DRAWN BY: O.E. WATTS DATE: 10-23-19 DWG. NO.: 17-4958-06	APPROVED BY: PRDJ. NO. DWG.	REVISIONS	OLIVER E. WATTS CONSULTING ENGINEER COLORADO SPRINGS	PROJECT 16140 OLD DENVER ROAD PART NW1/4 SEC. 26, T.11S., R.67W. 6TH P.M. EL PASO COUNTY	SHT. NAME CONSTRUCTION DOCUMENT COVER SHEET	SHT. NO. 1 OF 4

CD_V9.pdf Markup Summary

FIGURE OS-2 TYPICAL OUTLET STRUCTURE
FOR FULL SPECTRUM DETENTION

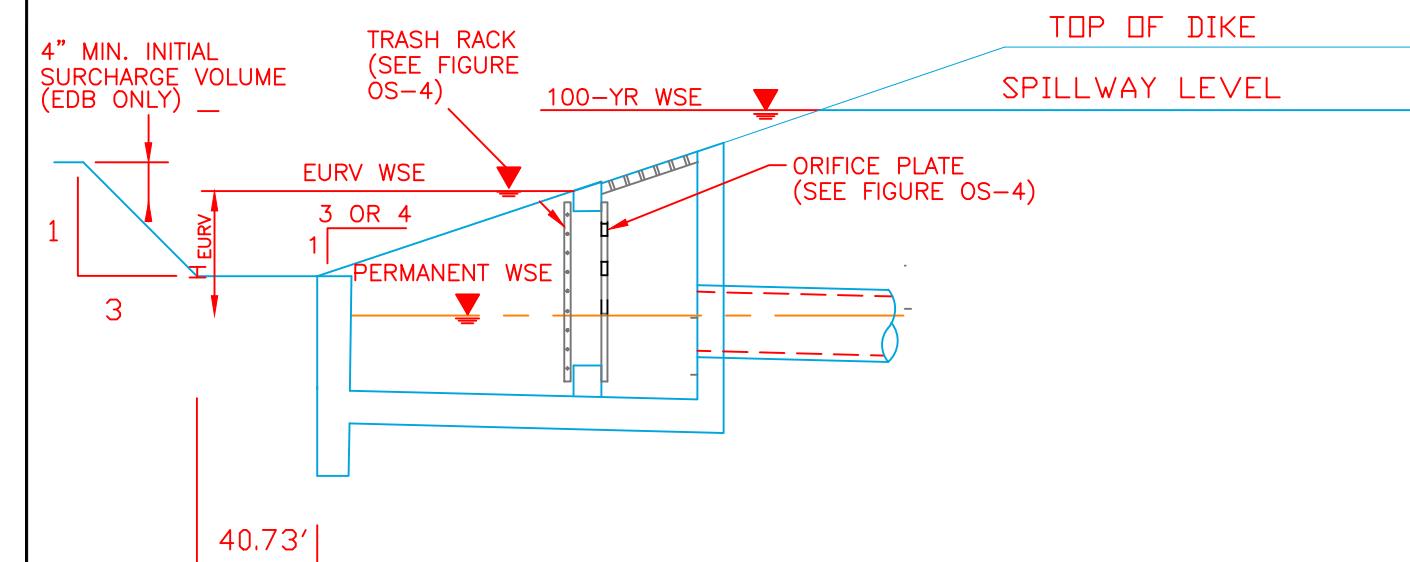
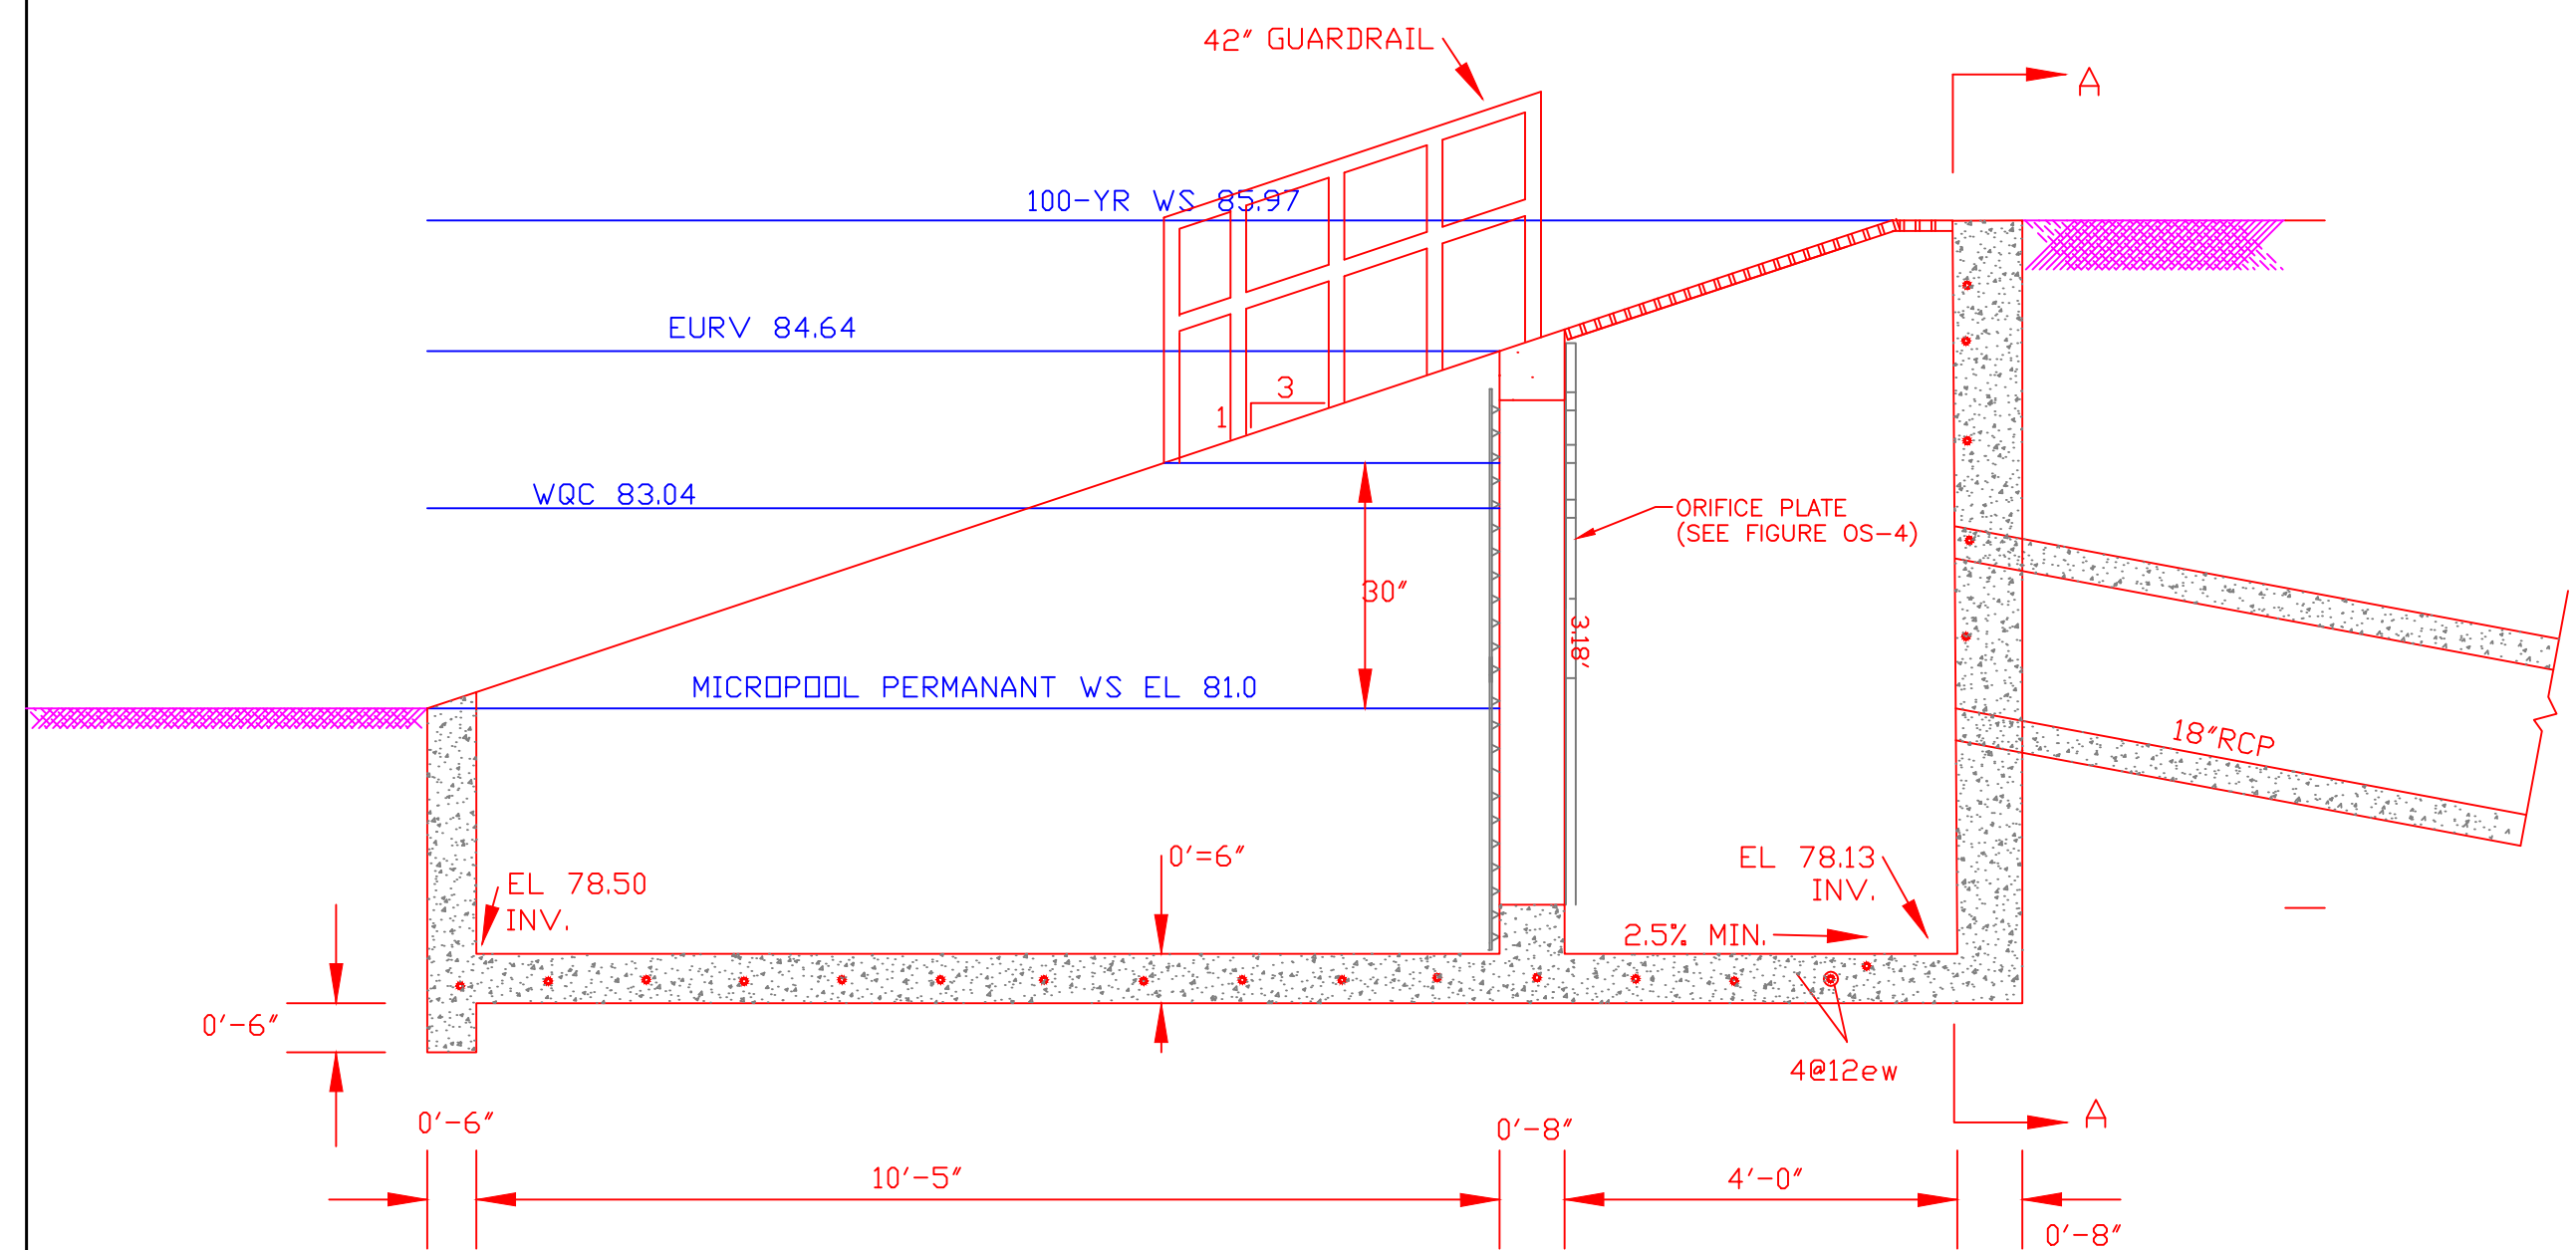
Figure OS-2 is not consistent with the outlet works profile.
Update Figure OS-2
